K/19/19/HH – Little Tangle, Middle Way, East Preston BN16 1SB

We write in connection with the planning application K/19/19HH.

Proposed Ground Floor Plan

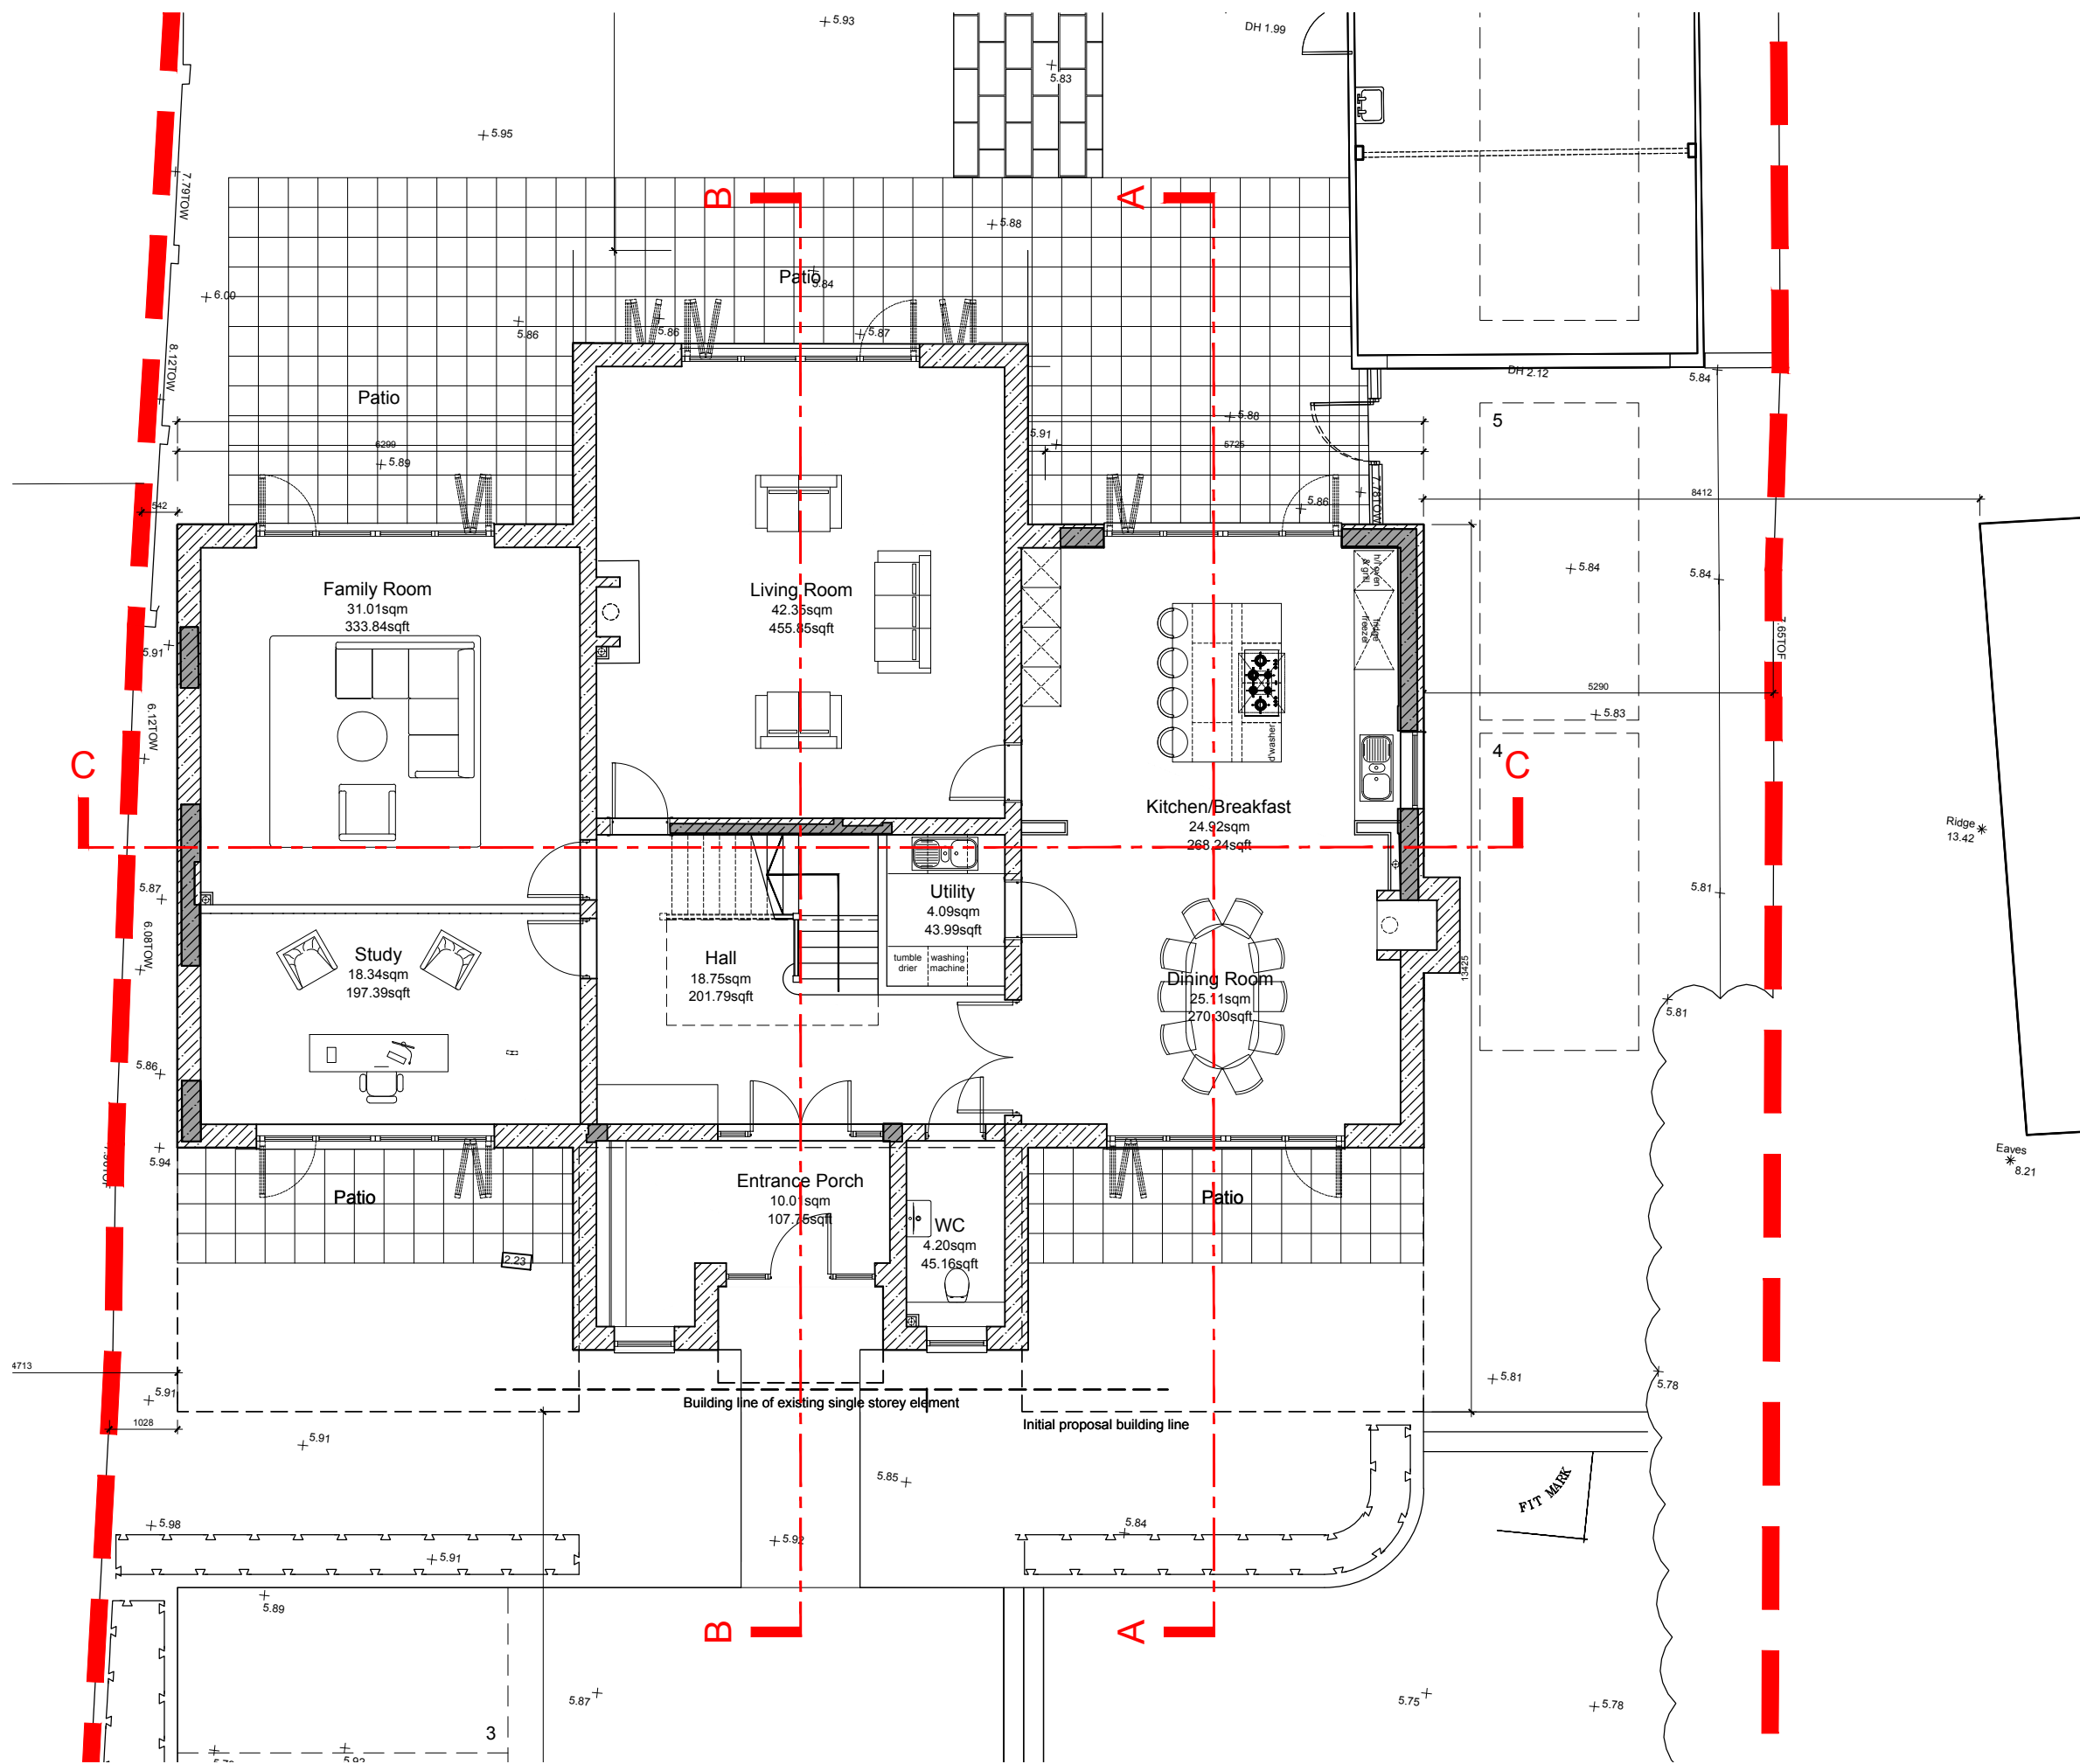
3. Whilst the ground floor m2 footprint is relatively unchanged, the shape of the footprint is different to today. The proposed rear development extends the footprint beyond the line of the current building and that of The Poynings, this is compounded by the fact that this will be a 2-storey extension 3.4m higher than it is today and 2m higher than The Poynings.

Most significantly we believe the rear bedroom/balcony gable element of the building would extend at least 1.5m beyond the line of The Poynings.

4. There is to be a window on the ground floor east elevation. One exists today but it is small, opaque and virtually invisible due to the height of the side fencing. It is unclear from the drawings if this is to be maintained or changed in anyway i.e. size, glass type etc. We are assuming any planning approval would require the current level of privacy to be maintained.
5. We note that there is to be no change to hedging given there is a substantial hedge on the east boundary that screens Little Tangle from The Poynings. The comments in the Design and Access statement are somewhat contradictory as they state there will be no changes to hedging and fencing and then go on to say that there will be. We would welcome clarification of what is intended.

Drawing Title
Proposed Sections

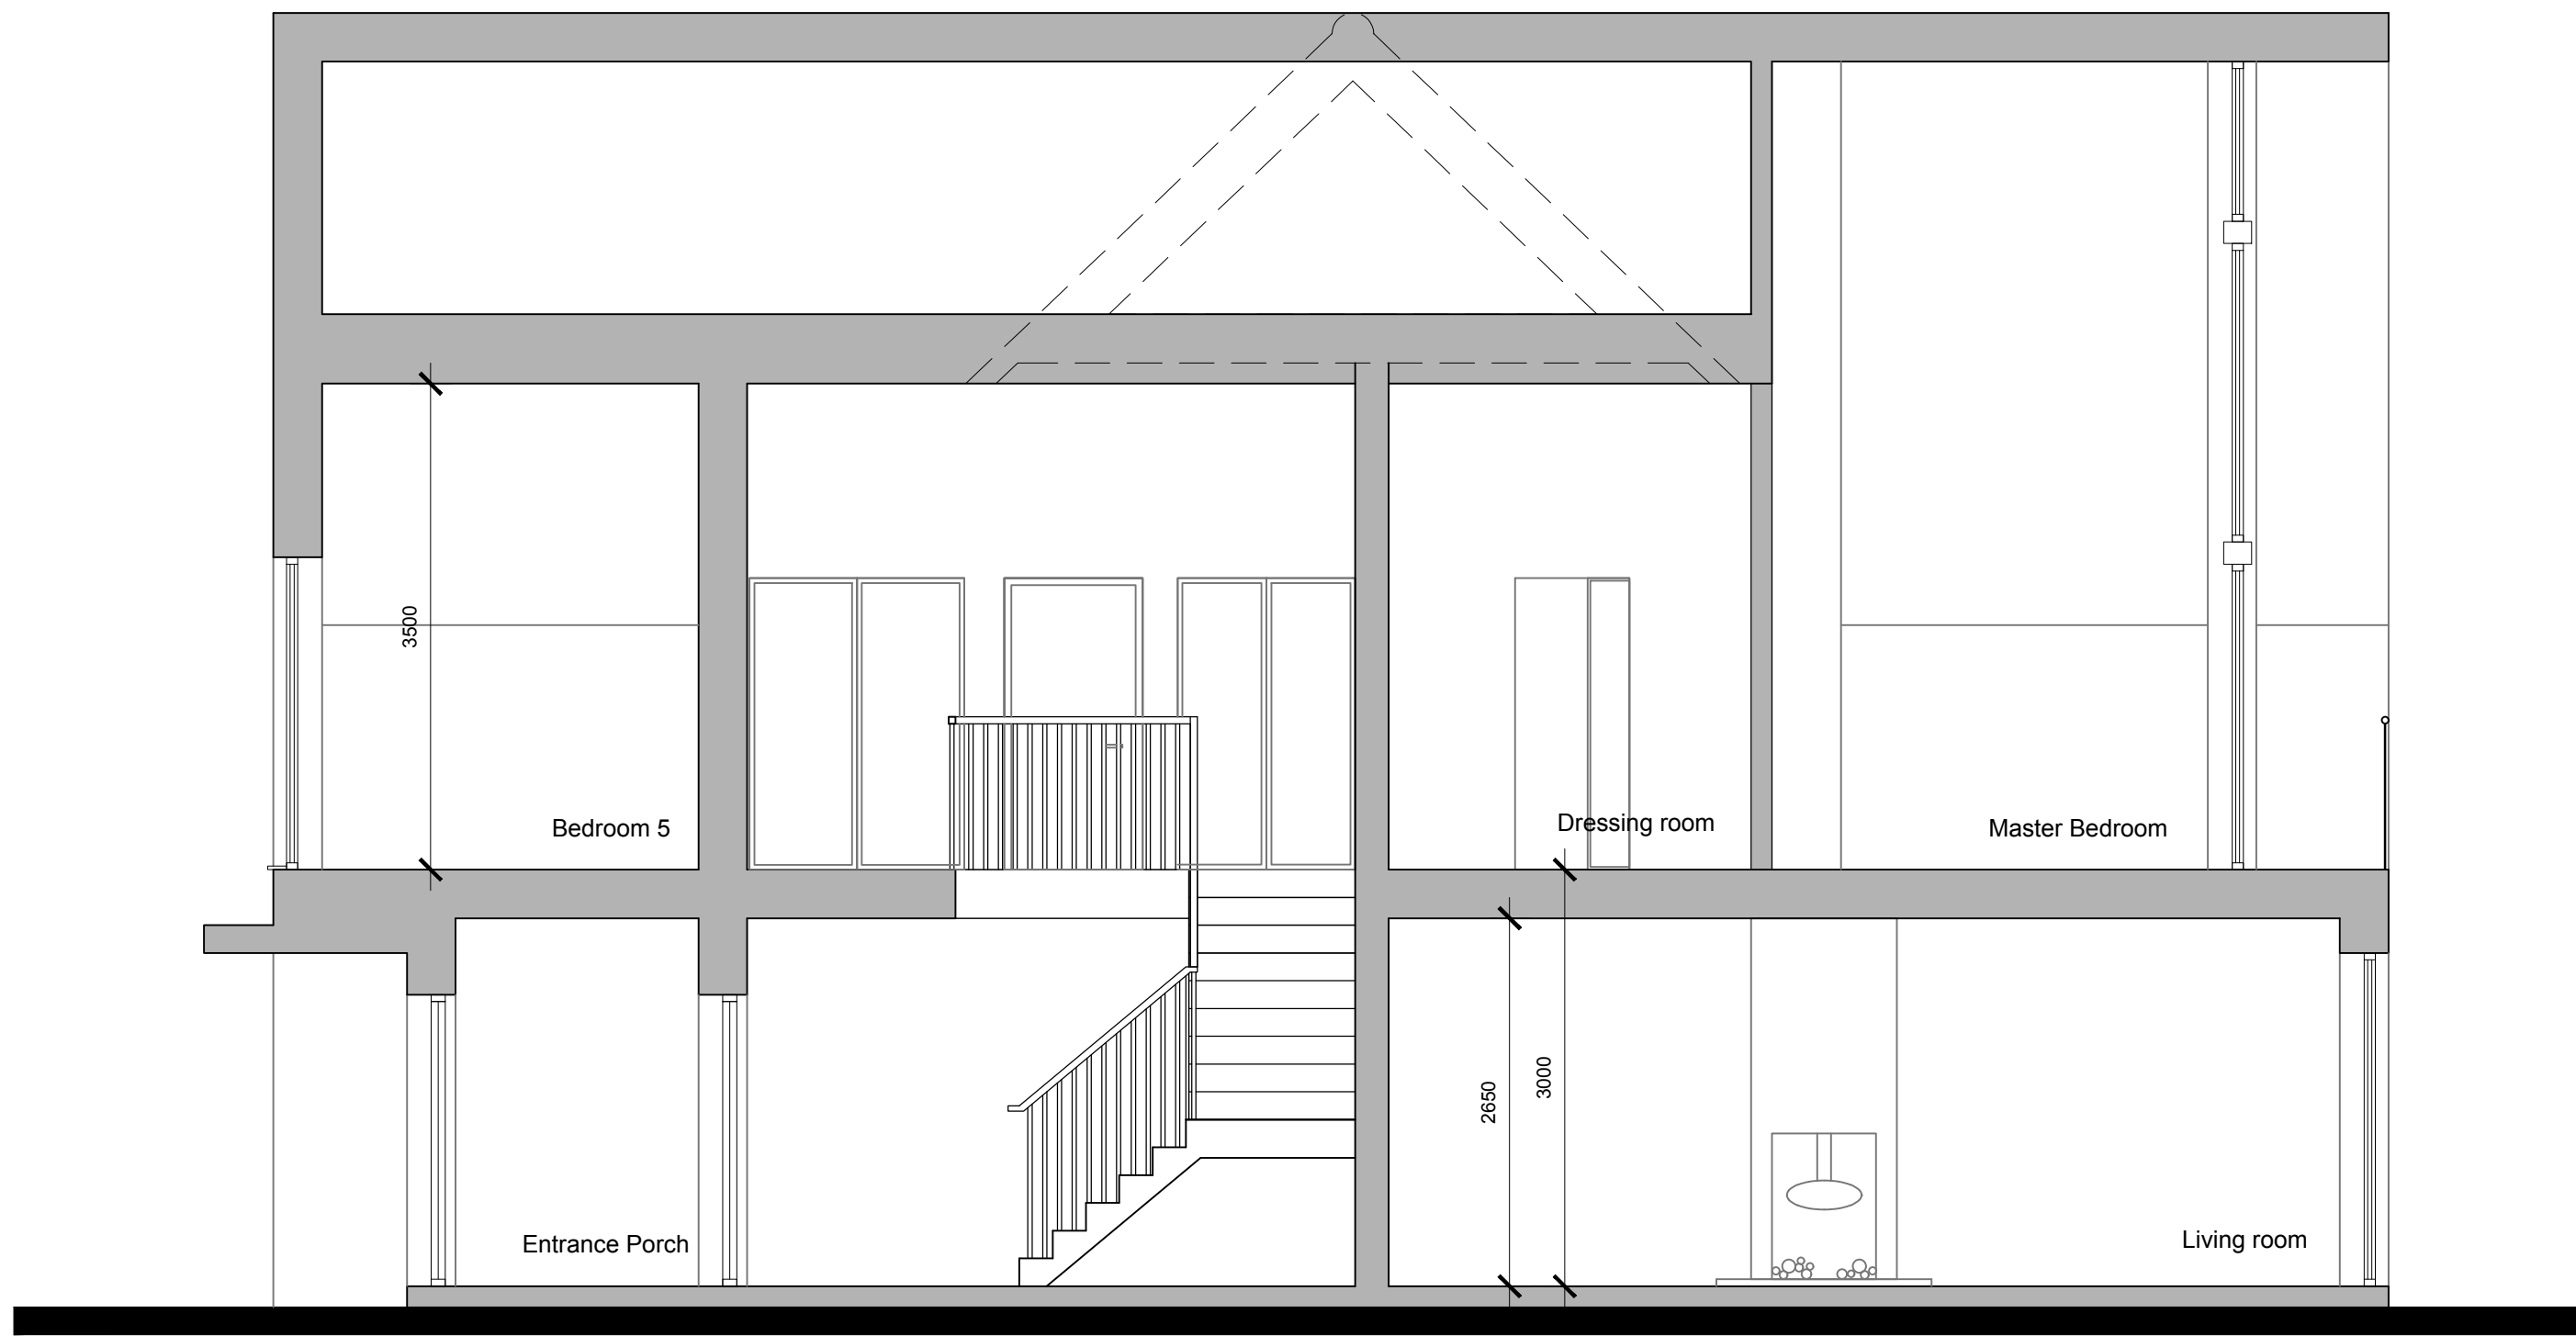
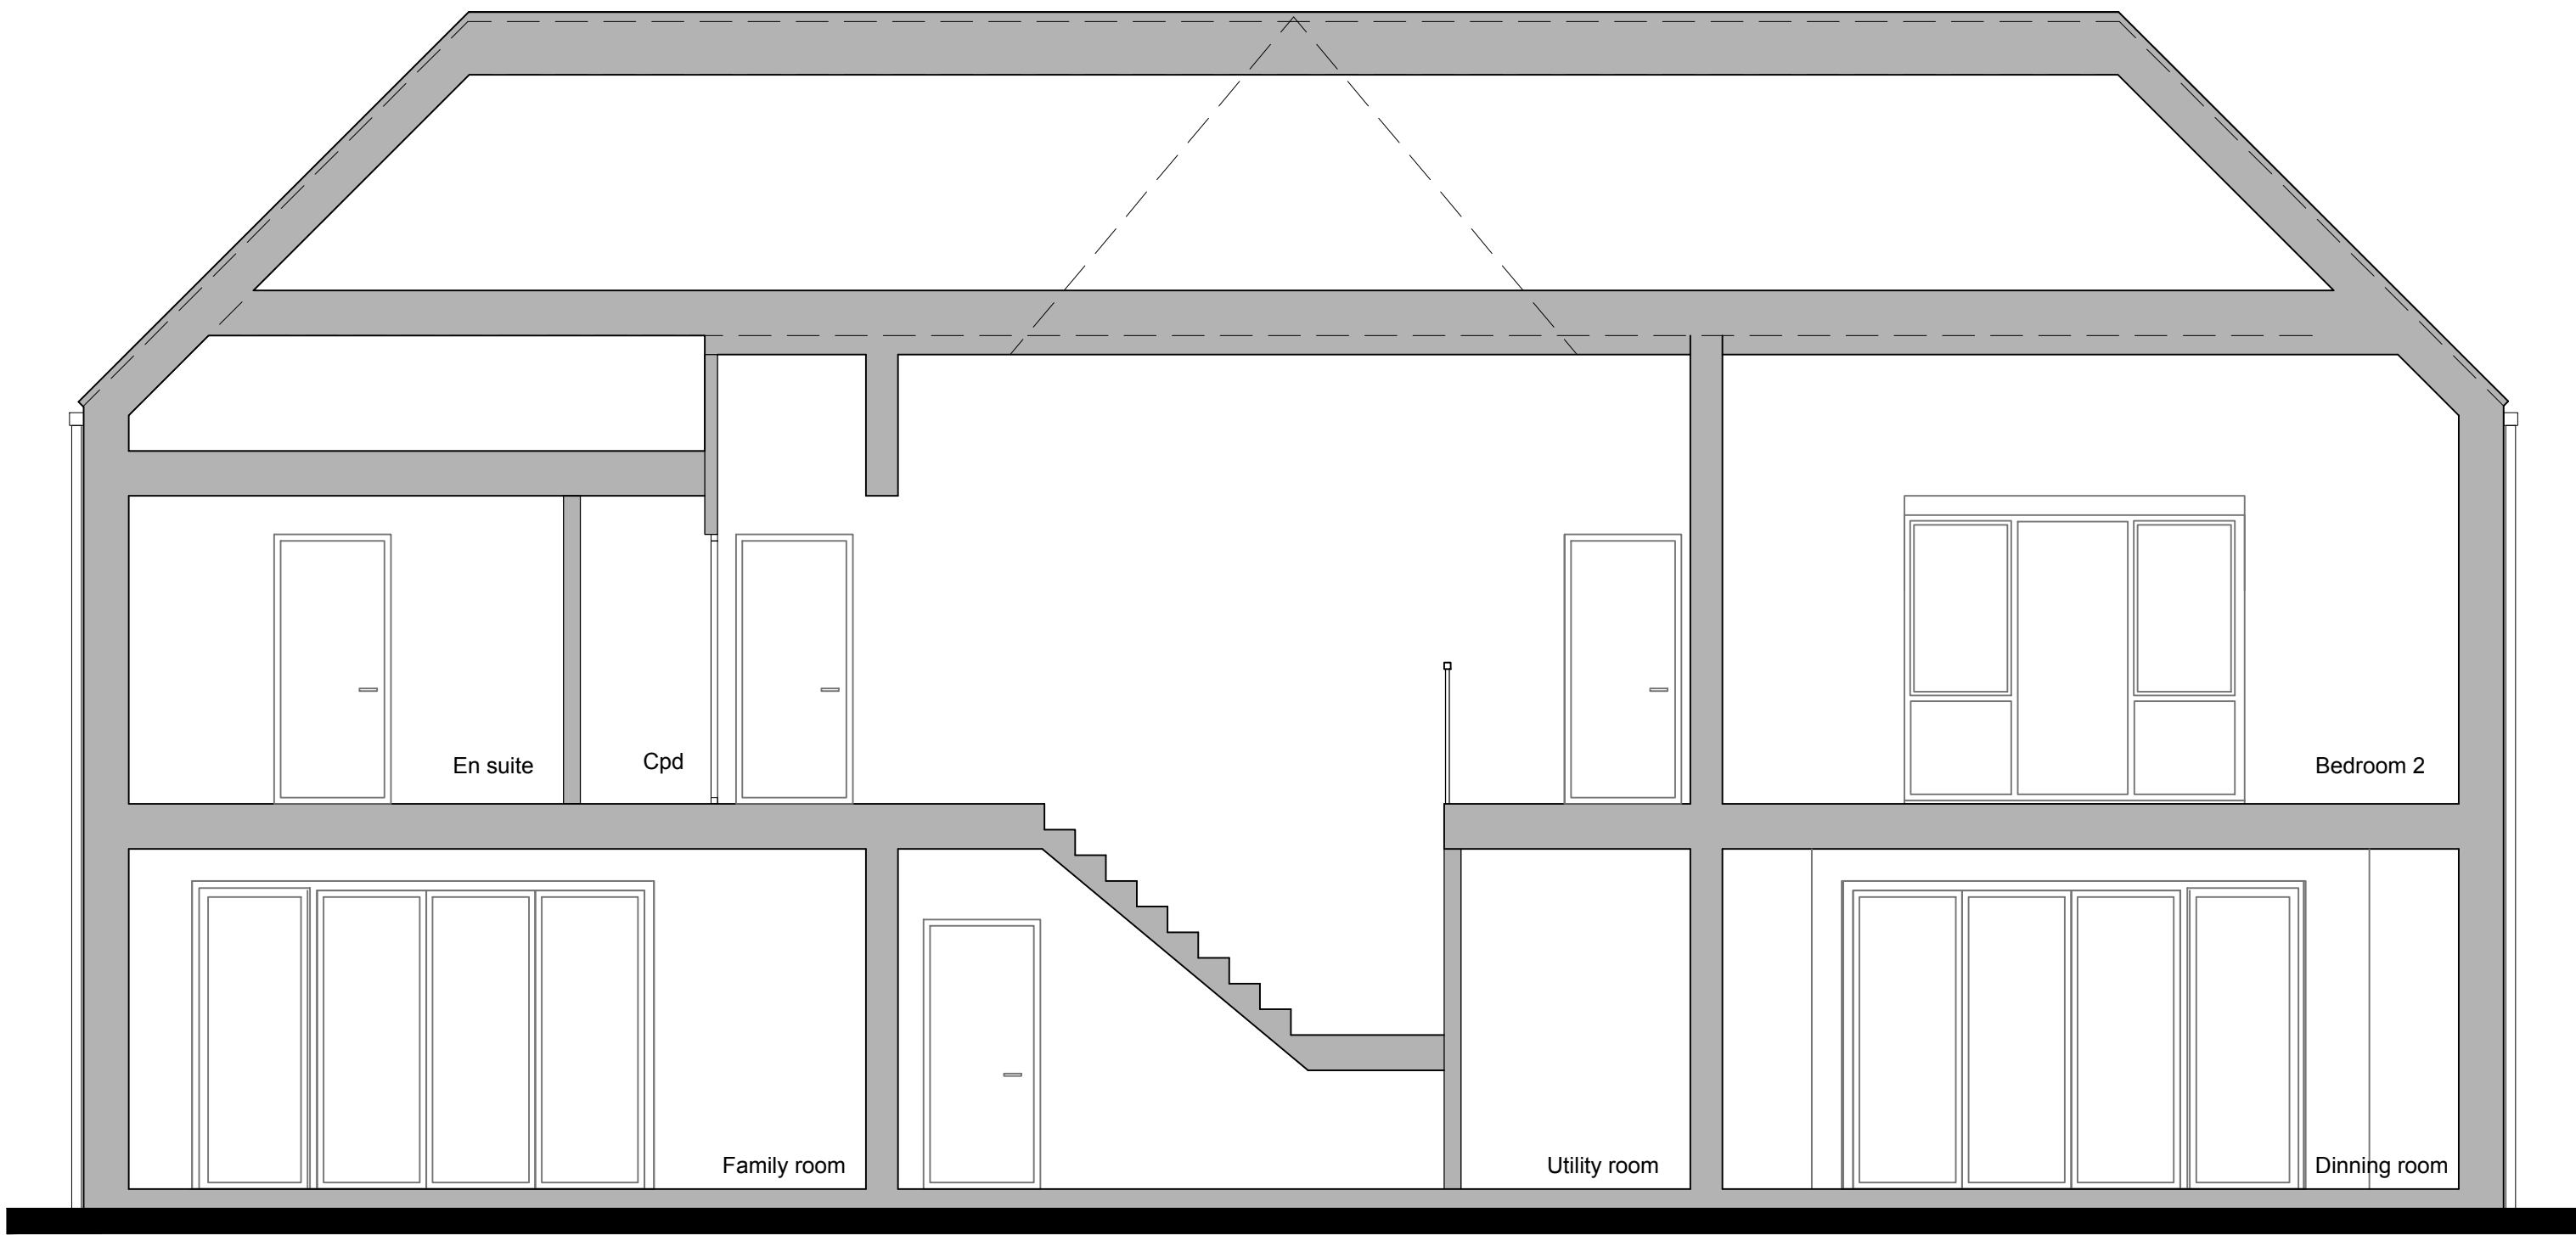
1. Little Tangle is in fact a bungalow that has accommodation in a small part of the roof area rather than a detached house. Consequently, whilst the planning application maintains the overall m2 footprint on the ground floor, it represents what appears to be in the region of a 2-2.5 times increase in the overall mass of the building by virtue of the first floor alterations.
2. The building ridge height is currently c12m and the proposed ridge height is c15.4m, an increase of 3.4m (a 28% increase). The Poynings (the east neighbour) ridge height is 13.4m. This is seen clearly in the document Proposed North and South Elevation 6702.20P1.

For the planning rules to be applied consistently the maximum ridge height for this development, as an extension, should be c11.5m.
